PRE-HEARING STAFF ANALYSIS

Rezoning Petition No. 2005-156

Petitioner: York Development Group

Location: Approximately 11.7 acres east of Lancaster Highway and north of Providence Road West

Sheet Title:  
**REZONING SITE PLAN APPROVAL TO PETITION #2005-156**  
 Sheet No: **R.1**

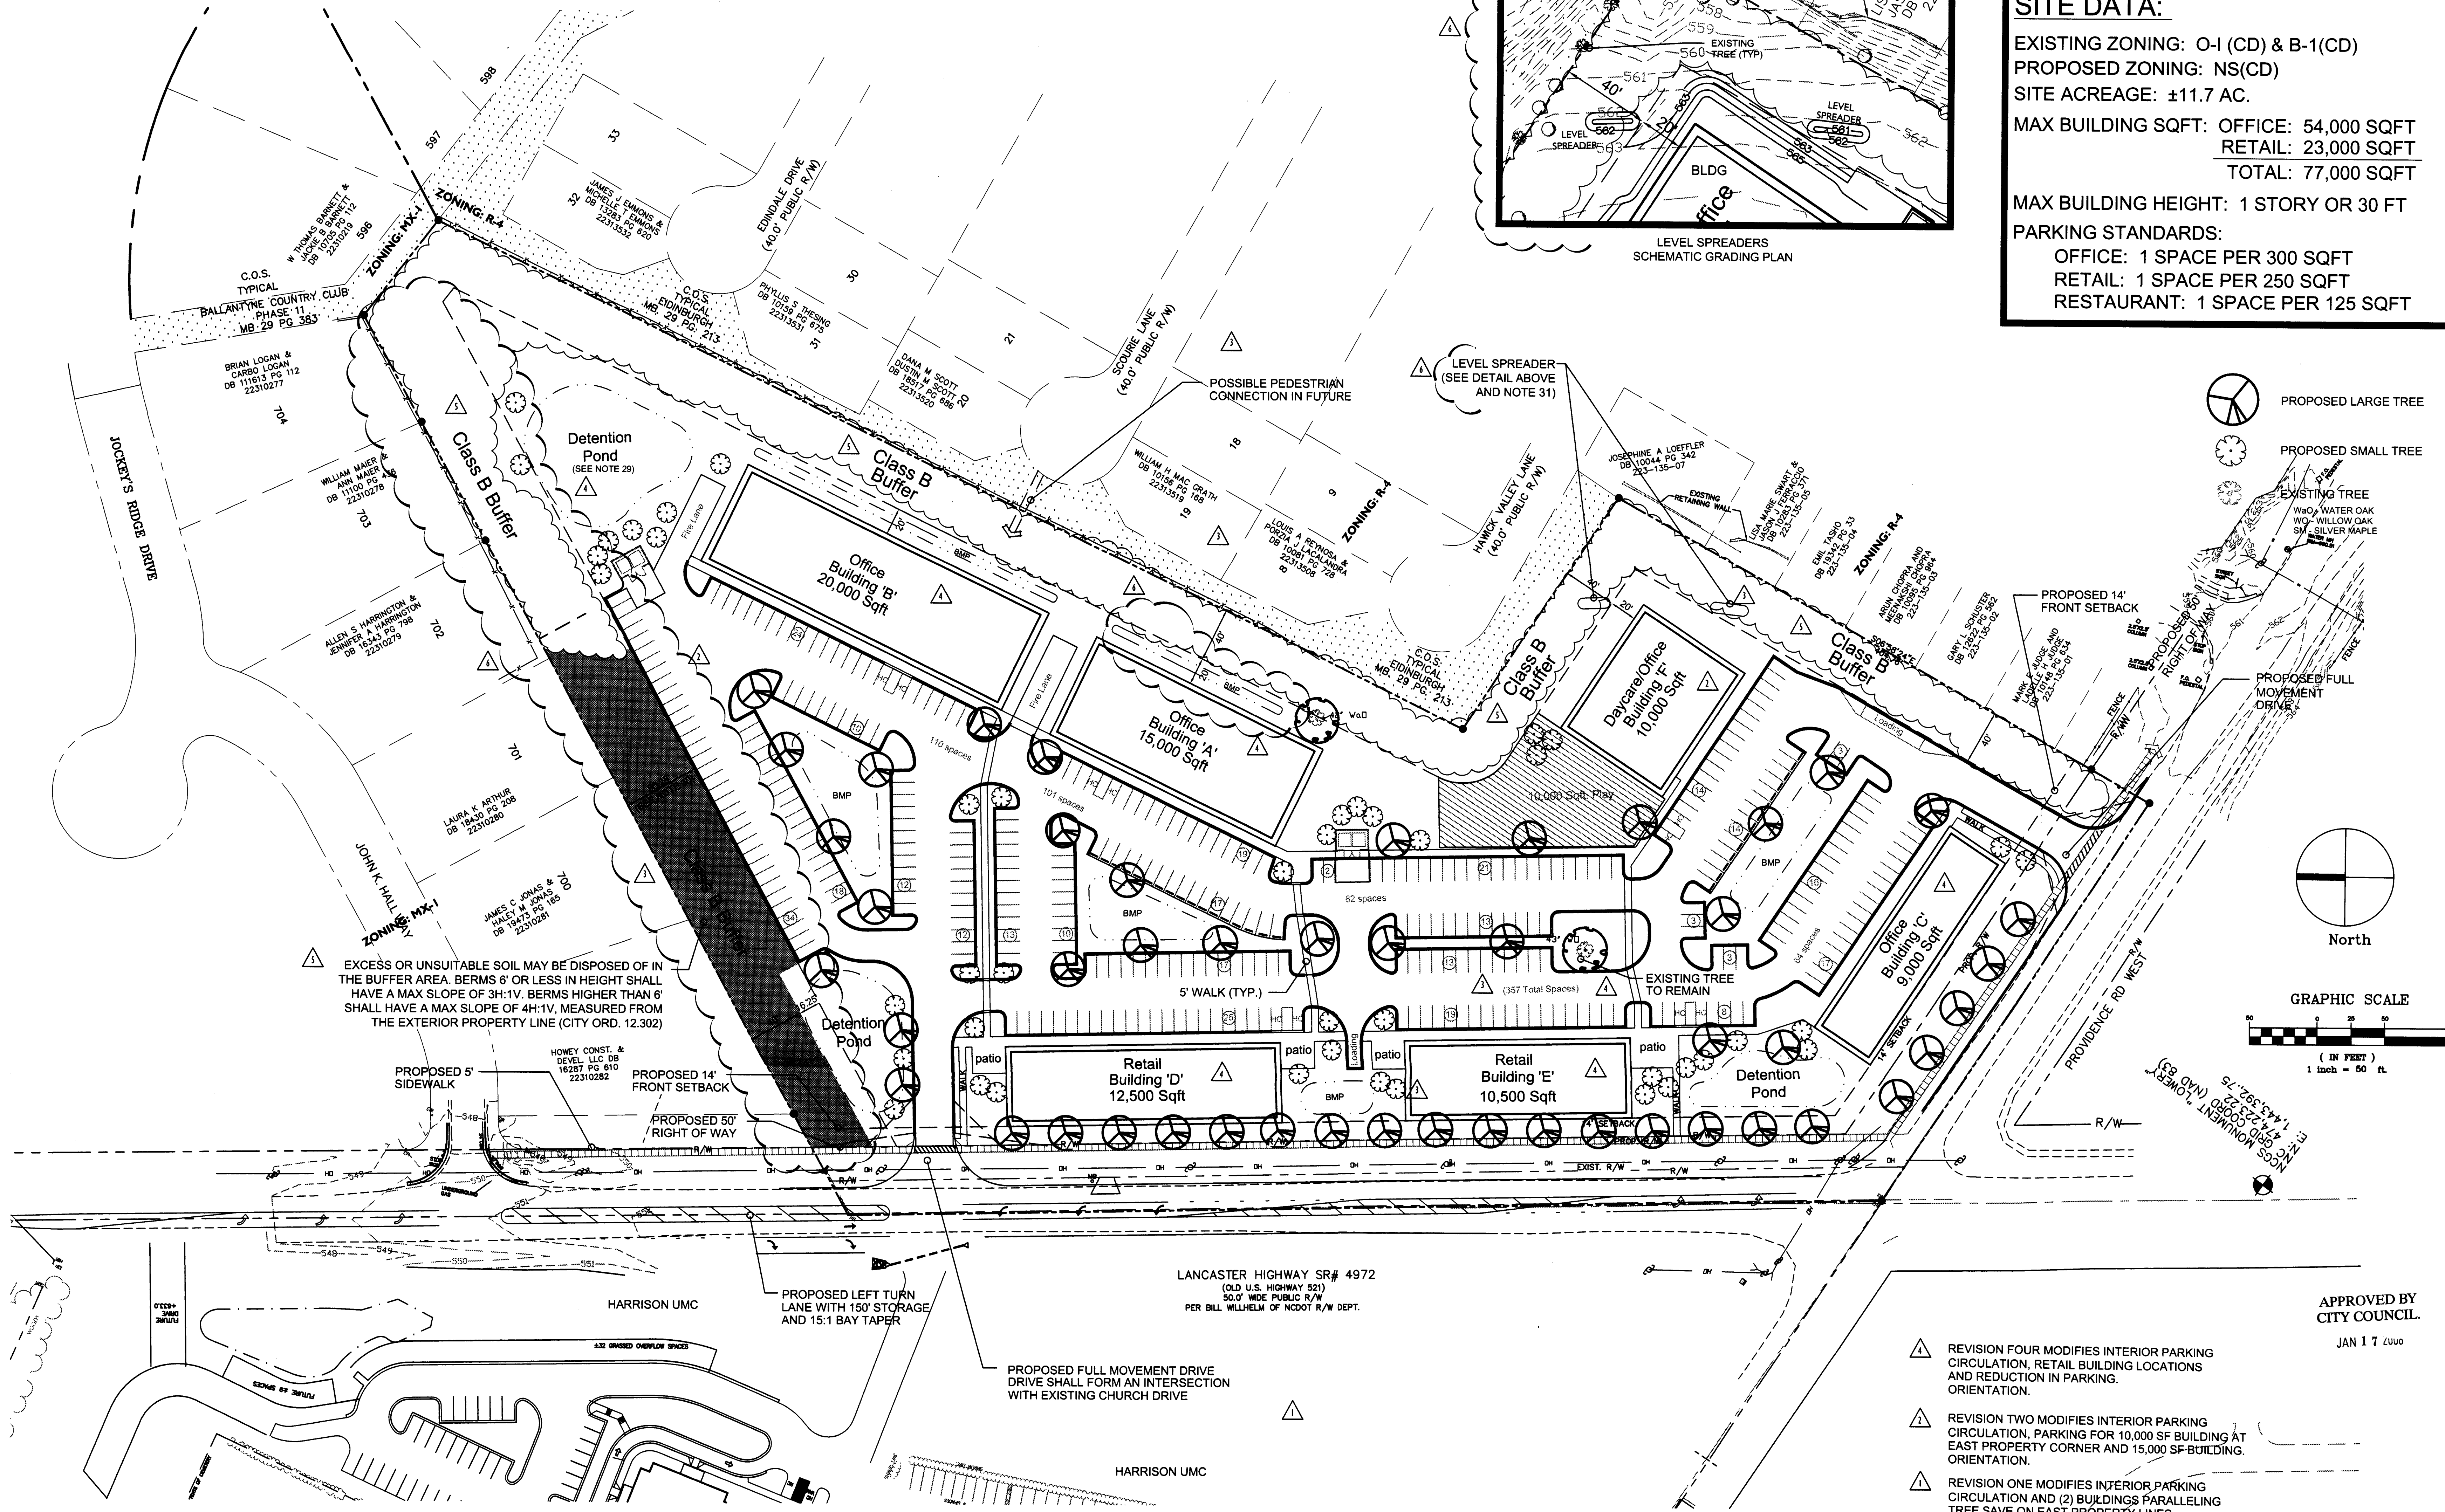
Traffic Impact / CDOT Comments. CDOT is opposing the right-in, right-out driveway on Lancaster Highway and requiring a left turn lane for the northernmost driveway. In the future, the driveway on Providence Road West will become right-in, right-out. CDOT is requesting that sidewalks be extended to the north and east to tie into existing sidewalks beyond the boundaries of this site. Right-of-way 50 from existing centerlines is needed for both thoroughfares. See attached CDOT memo for detailed comments.

CATS. CATS also requests the northward extension of the sidewalk on Lancaster Highway.

Storm Water. Storm Water Services has requested specific language for water quality improvements that are not included on the site plan. See attached memo for detailed request.

- The site plan needs to show sidewalks from the front entrances of buildings B, D, E, and F to the public sidewalks.
- Provide pedestrian-scale lighting throughout site.

- There should be a planting strip between the driveway and sidewalk at the entrances.
- The dumpsters should not be located at the terminus of the entrance drives. They become the focal point by location.

- The notes recommended by Storm Water Services need to be incorporated into the plan.
- CDOT's concerns need to be satisfied.
- There are a large number of significant trees on the site. The petitioners need to commit to the preservation of a larger number of those trees.

- Additional commitments to "four-sided" architecture need to be made.
- Notes need to be added to the plan to ensure that the area between the buildings and the street do not appear to be utility/service dominated. That necessary equipment needs to be placed between the buildings and screened.

- A note needs to be added that supplemental plantings will be made in the buffers if necessary.
